Application Reference: A/134/24/DOC Site Name: Broadlees Dappers Lane Angmering BN16 4EN	Initial Issue Date: 17.10.2024 Issue Date: 06.02.2025 Reviewer Reference: ADC/EXT2/D2134/63
---	---

ADC Drainage Comments	Designer Response	ADC Drainage Comments	Designer Response	ADC Drainage Comments
Date:	21/03/2024 [A/38/24/DOC]	26/07/2024	17/10/2024	18/11/2024	06/02/2025
Condition Number: 15 (Surface Water Drainage Design)

Surface Water Drainage Comment Tracker

DRAWN	DATE	CHECKED	DATE	APPROVED	DATE
SG	09.10.2025	MG	09.10.2025	MG	09.10.2025
CONTRACT NO:	23086				
PROJECT NO.	ORIGINATOR	ZONE	LEVEL	TYPE	DISCIPLINE NUMBER
23086	ARC	XX	XX	DR	D - 5010 - P4

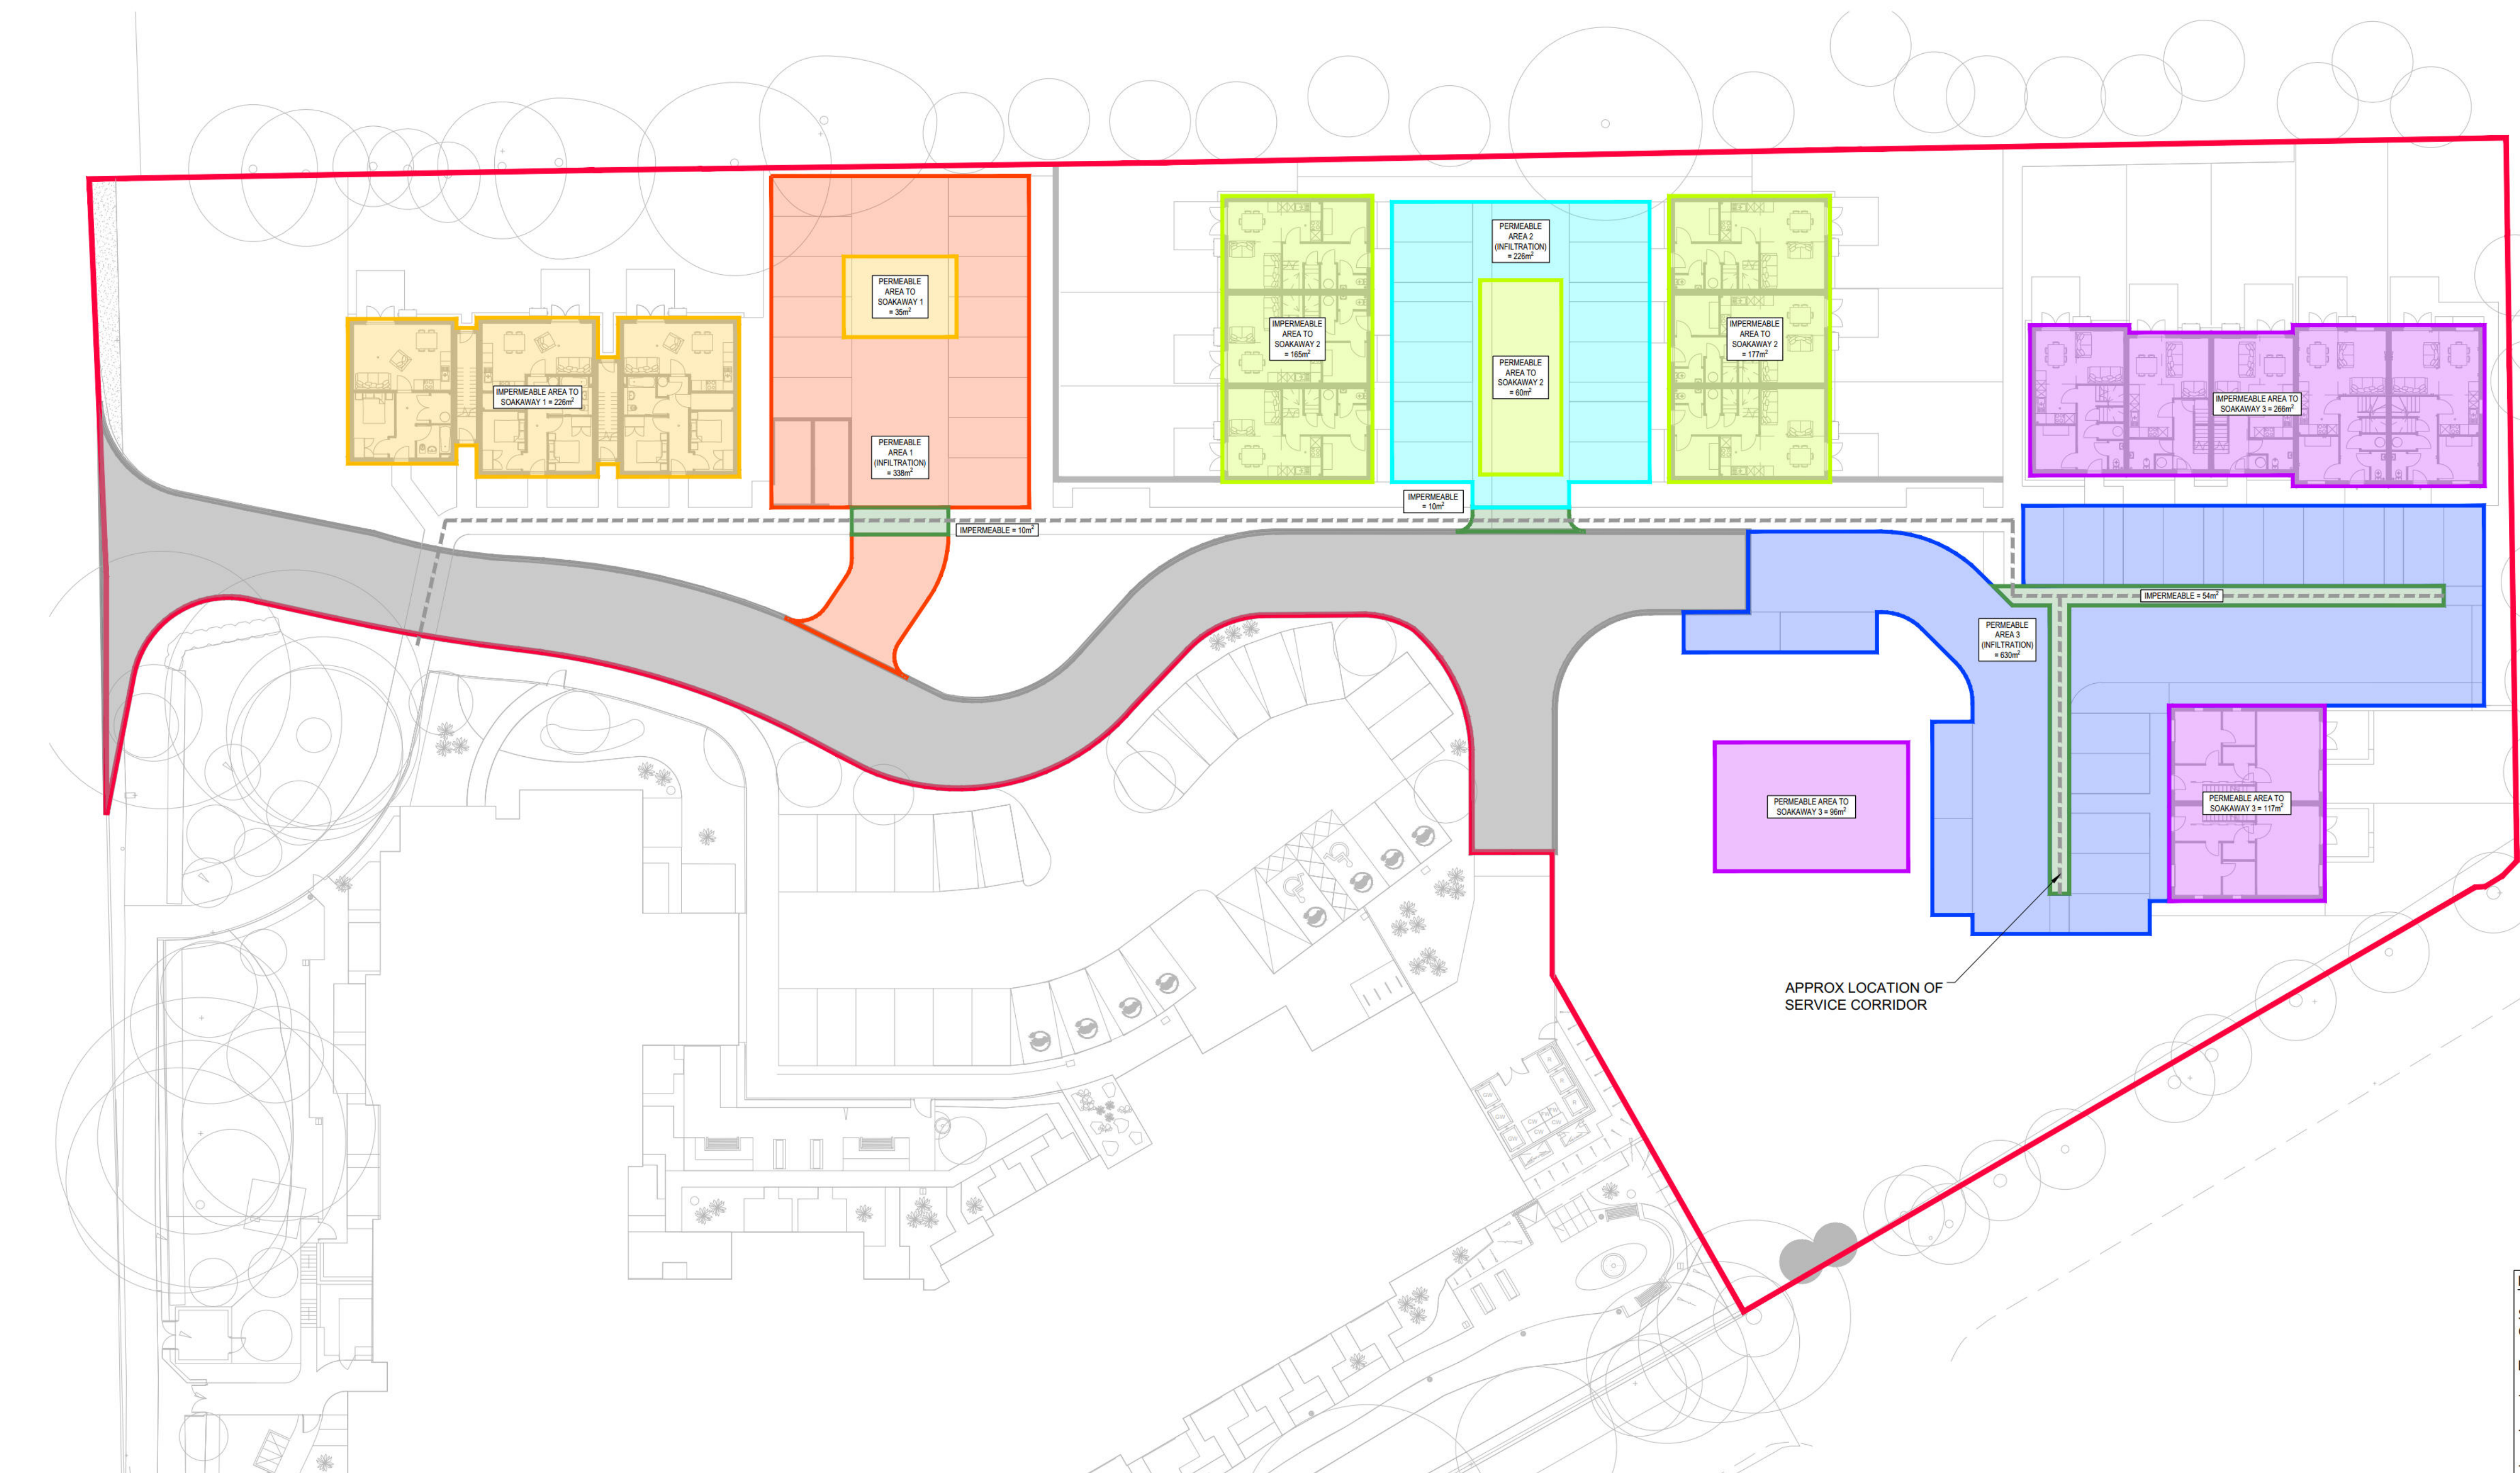
4.	Please provide a copy of your catchment area plans together with any classification of urban creep being applied.	Catchment areas shown on ARC drawing 23086-ARC-XX-XX-DR-D-5010. drawing included in Drainage Strategy Report. urban creep noted in report.	Noted. Comment closed.		
	Hydraulic Calculations:

CORRIDOR SERVICE DETAIL 1
SCALE 1:20

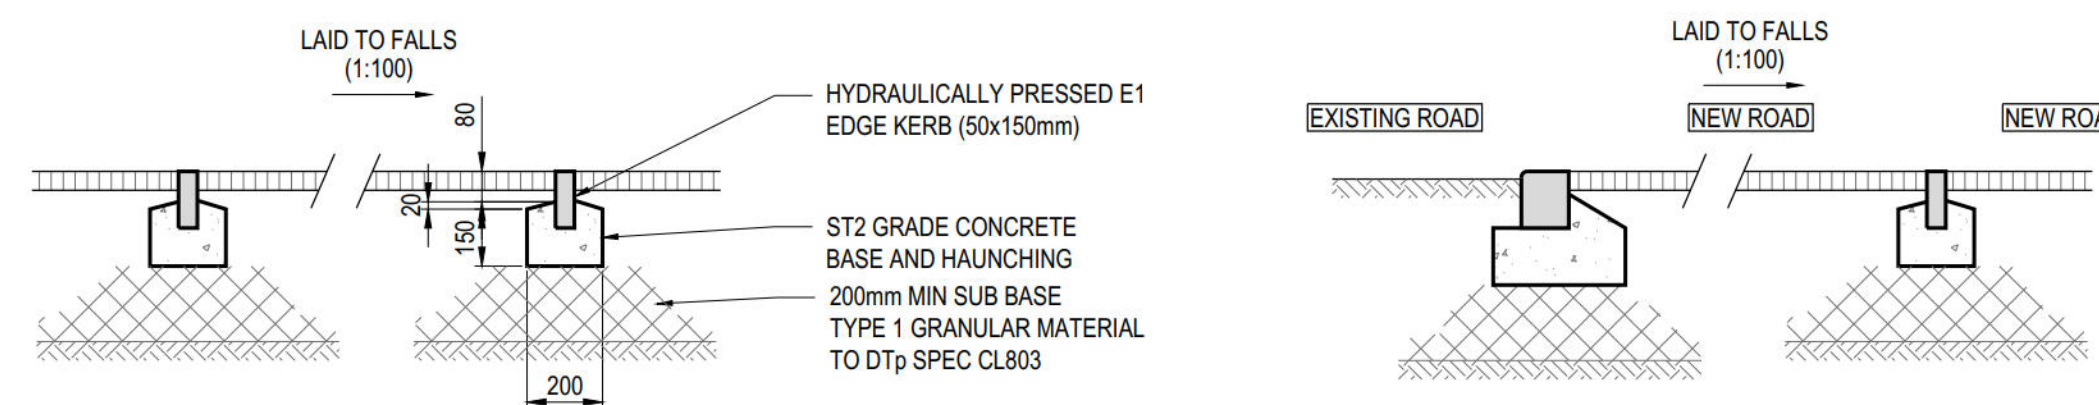
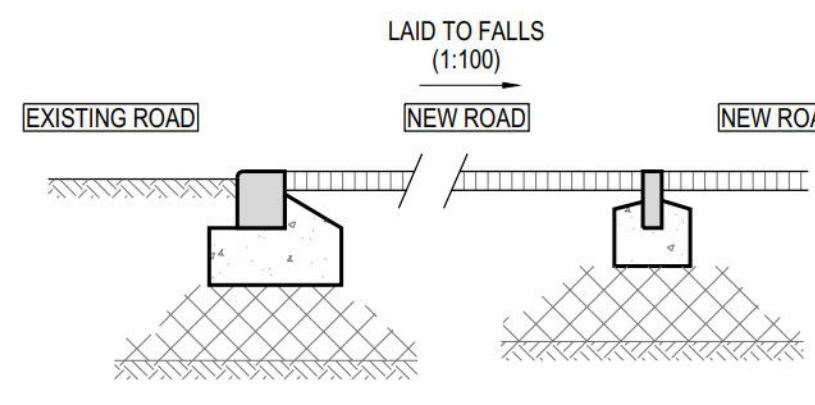
17.	Site elevation design has not been provided so levels, crossfalls, overland flow, check dams, other protective measures to 3rd party land/highway cannot be reviewed.	Proposed contours are indicated on the ARC flood exceedance route drawing 5011-P1.	As cited above the exceedance drawing is insufficient in respect of an engineers design. Comment outstanding.	Refer to updated Appendix 'E' drawing 23086-ARC-XX-XX-DR-D-5011-P2	Noted. Comment closed.
